Date: 15th March 2019

**CONVERSION OF AN EXISTING RESTAURANT (A3) TO CREATE TWELVE APARTMENTS (C3)
AND THE SITING OF FOUR HOLIDAY LETS
DOG AND PARTRIDGE, HESKETH LANE, CHIPPING, PR3 2TH
APPLICATION NO. 3/2018/0786**

I refer to the following comments received from the Lead Local Flood Authority dated 21st December 2018 with regards the above planning application. The comments are repeated below along with our responses so that the LLFA may make a substantive response to the application.

# PROPOSED BLOCK PLAN

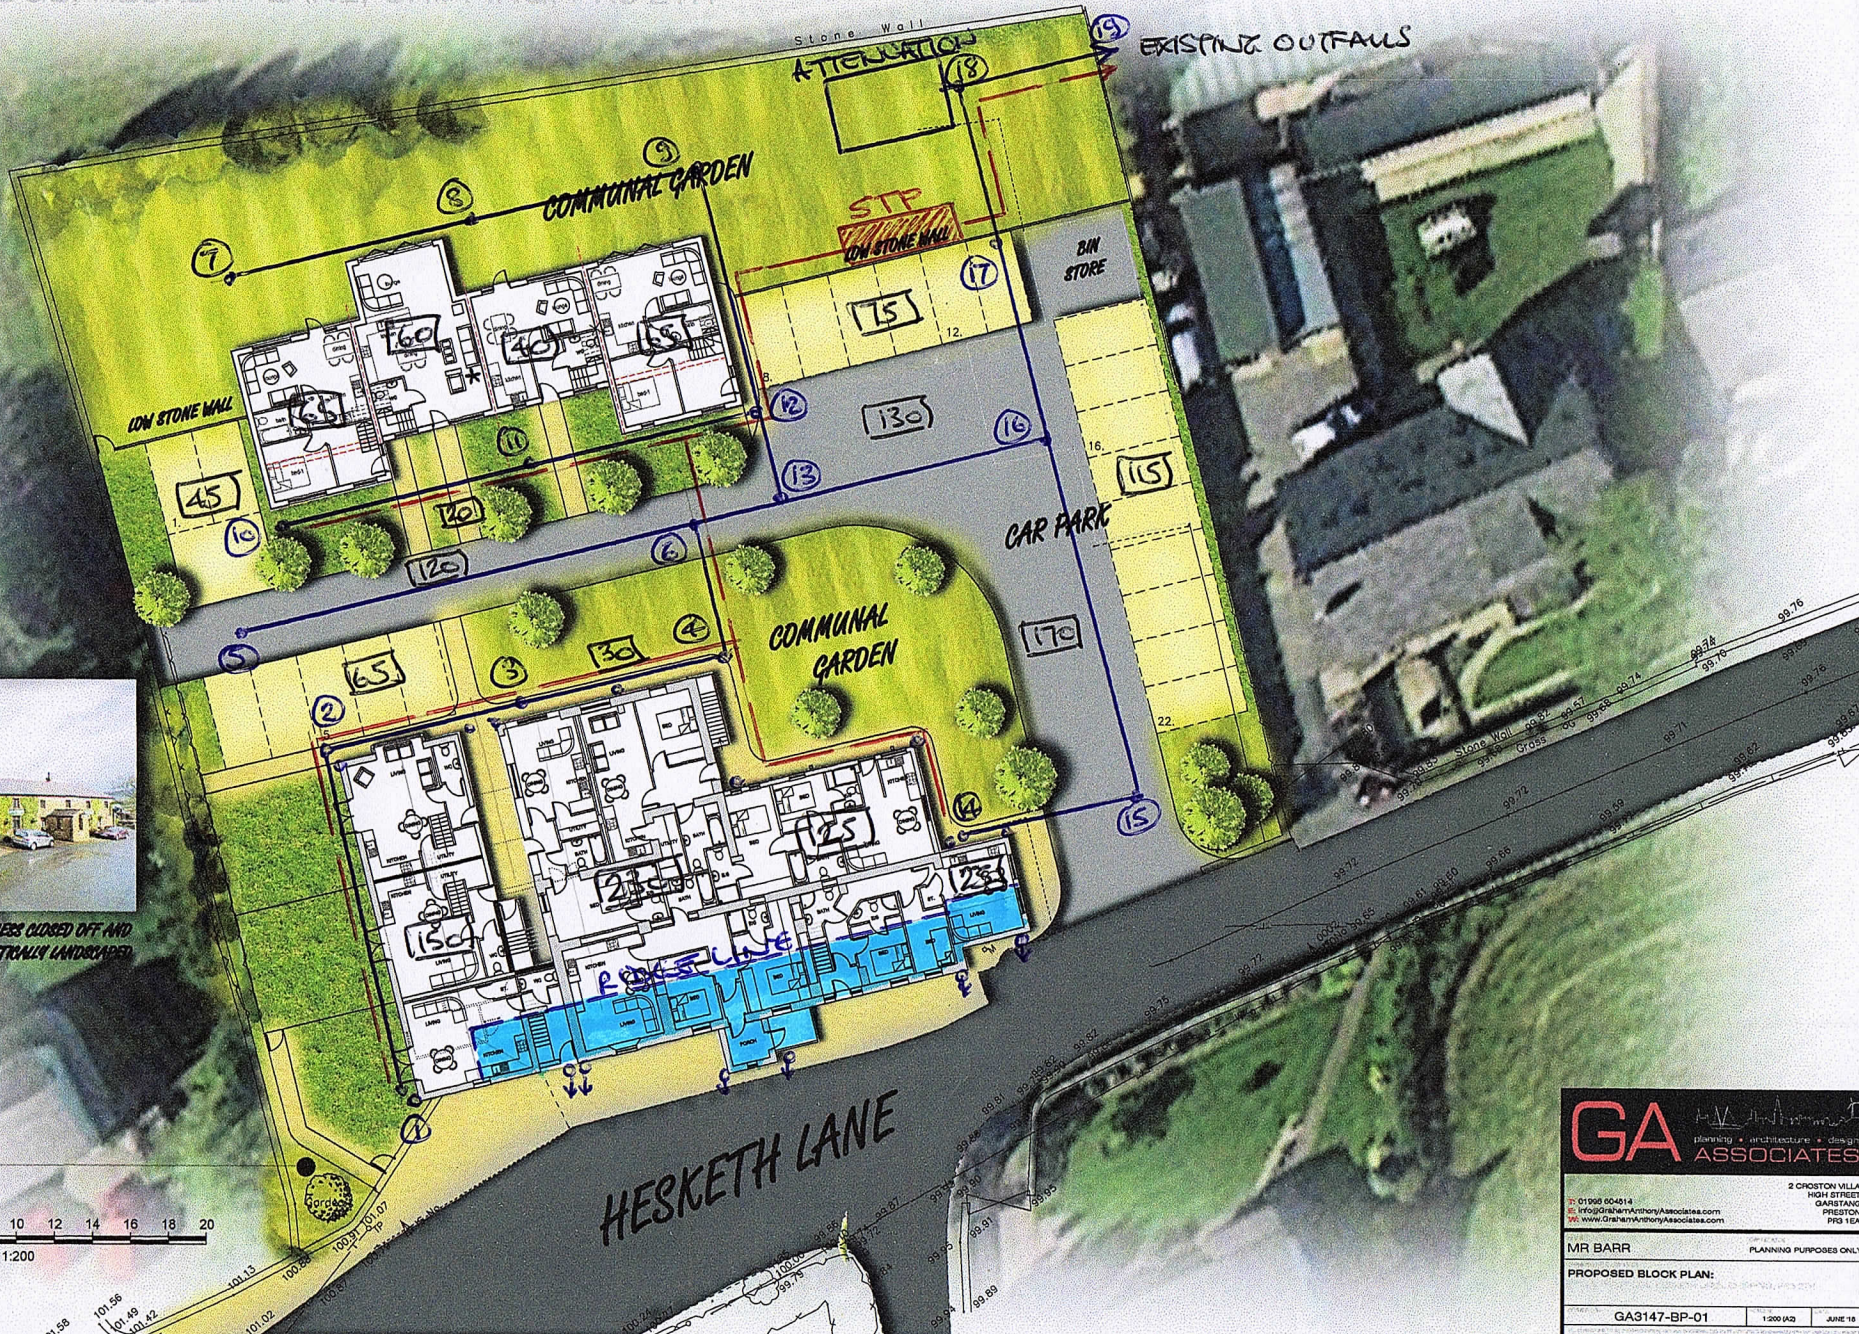
3. The preliminary surface water drainage layout plan (appendix B of the drainage strategy report) appears to show surface water from a small area of the site being drained to ground (i.e. the plots adjacent to Hesketh Lane). This arrangement conflicts with the conclusions of the applicant's drainage strategy report, which suggest that infiltration will not be possible due to existing ground conditions. This will need to be brought to the attention of the applicant so that further clarification can be provided in this regard. Should the applicant intend to proceed with the use of soakaways for part of the site drainage, then they will first need to demonstrate that they have worked through an appropriate assessment carried out under Building Research Establishment (BRE) Digest 365 revised 2016. This is to confirm the suitability of soakaways within the development site. If soakaways are shown to be unsuitable, then the applicant will need to provide an alternative method for draining this area of the site.

Response

The words 'to ground' within the drainage strategy does not mean via infiltration but onto the ground as what currently happens, i.e. the downpipes for the small area of building roof discharge onto the ground.

The building structure is remaining unchanged. There is difficulty in providing a drain across the front of the building due to its close proximity to the public highway. The down pipes at the corners of the building frontage can be connected to the proposed drainage system and have been taken account of within the calculations. The downpipes on the building entrance porch roof will discharge onto the ground or into planters.
